CITY OF ALBUQUERQUE

Re: 4Hg-LLC- Alteration Level 2
10520 Research Rd SE
Traffic Circulation Layout
Engineer's/Architect's Stamp 11-20-19 (M21D022)

Based upon the information provided in your submittal received 12-04-2019, the above referenced plan cannot be approved for Building Permit until the following comments are addressed:

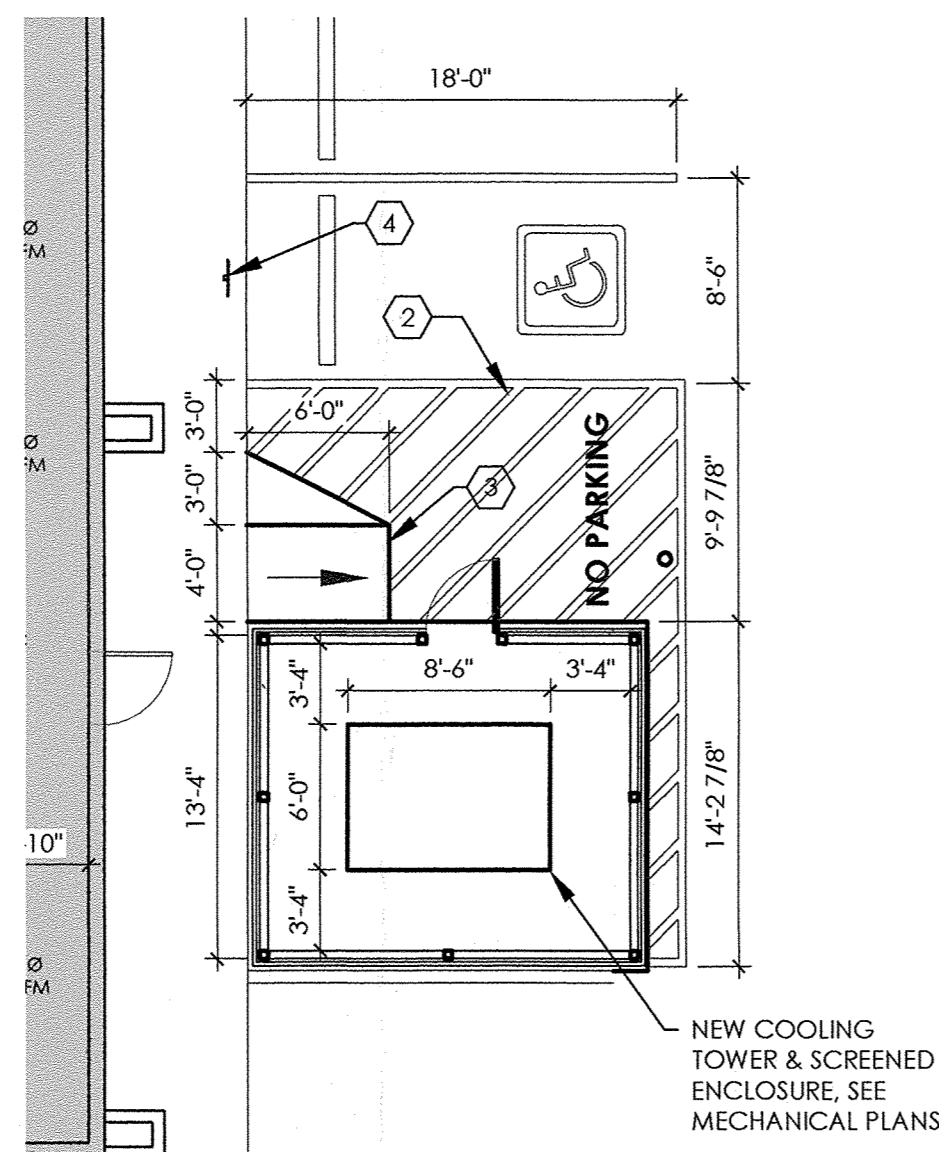
1. Refuse vehicle maneuvering shall be contained on-site.The refuse vehicle shall not back into the public right of way.; provide a copy of refuse approval.
2. Add a note stating "All broken or cracked sidewalk must be replaced with sidewalk and curb & gutter." A build note must be provided referring to the appropriate City Standard drawing.
